Ms Elizabeth Halton
Byfields,
Nyton Road
Westergate
PO20 3US

Please ask for: Nicola Moore
Email: nicola.moore@arun.gov.uk
Telephone: Ext 37944
Our Ref: AL/40/21/PL
Your Ref:
Date: 9th April 2021

Application for Planning Permission

Development: Construction of 1 No. 3 bed dwelling. This application is in CIL Zone 2 & is CIL liable as new dwelling.
Location: Land Adjacent To Byfields Nyton Road Westergate PO20 3US

PROJECT	SCALE	SIZE
3YFIELDS_NYTON ROAD	1:100	A3
PO20 3US		
DRAWING No		REVISION

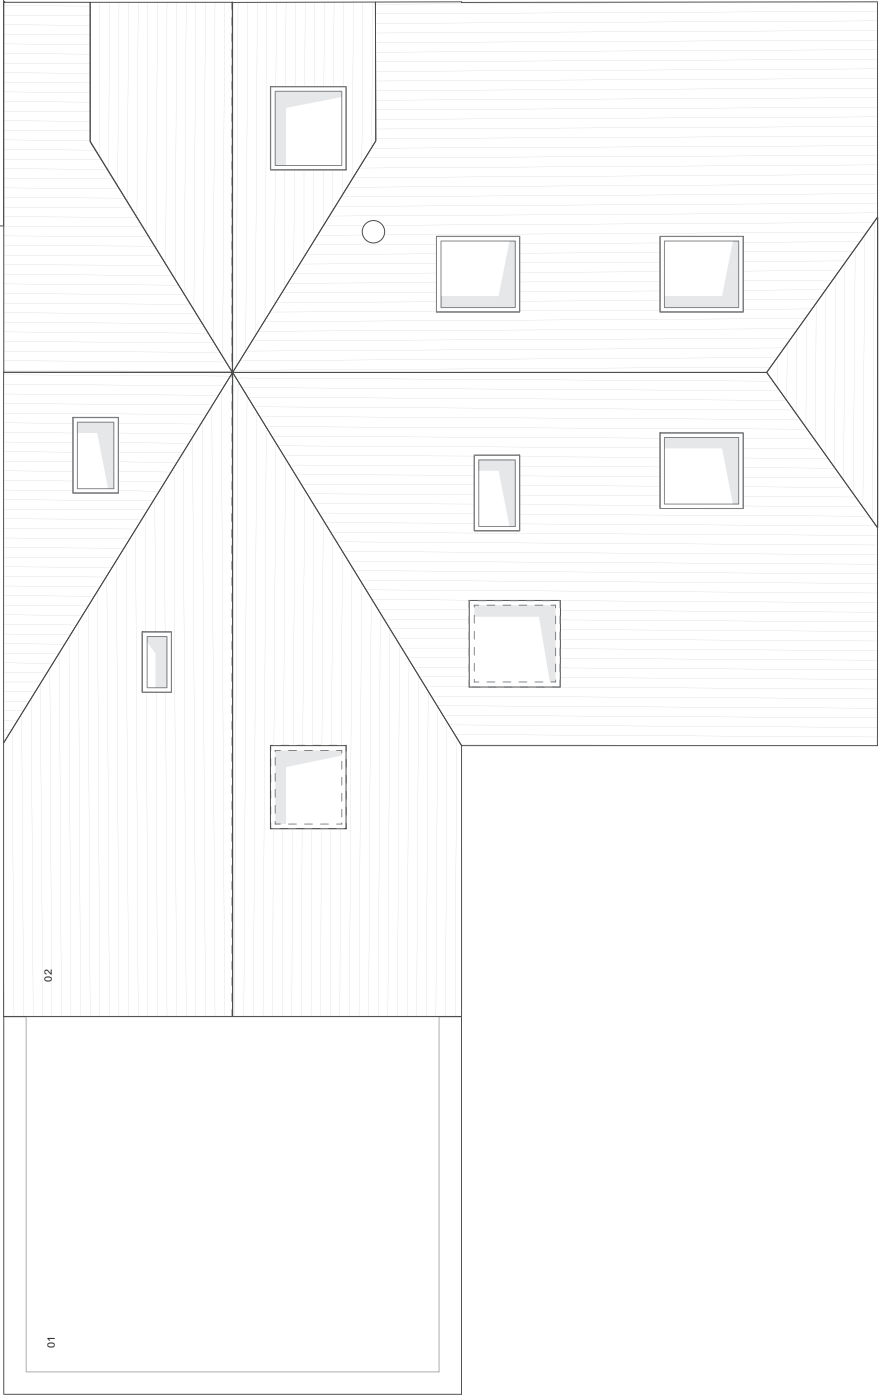
Block Plan

Please provide the measurements to boundaries from the proposed development.
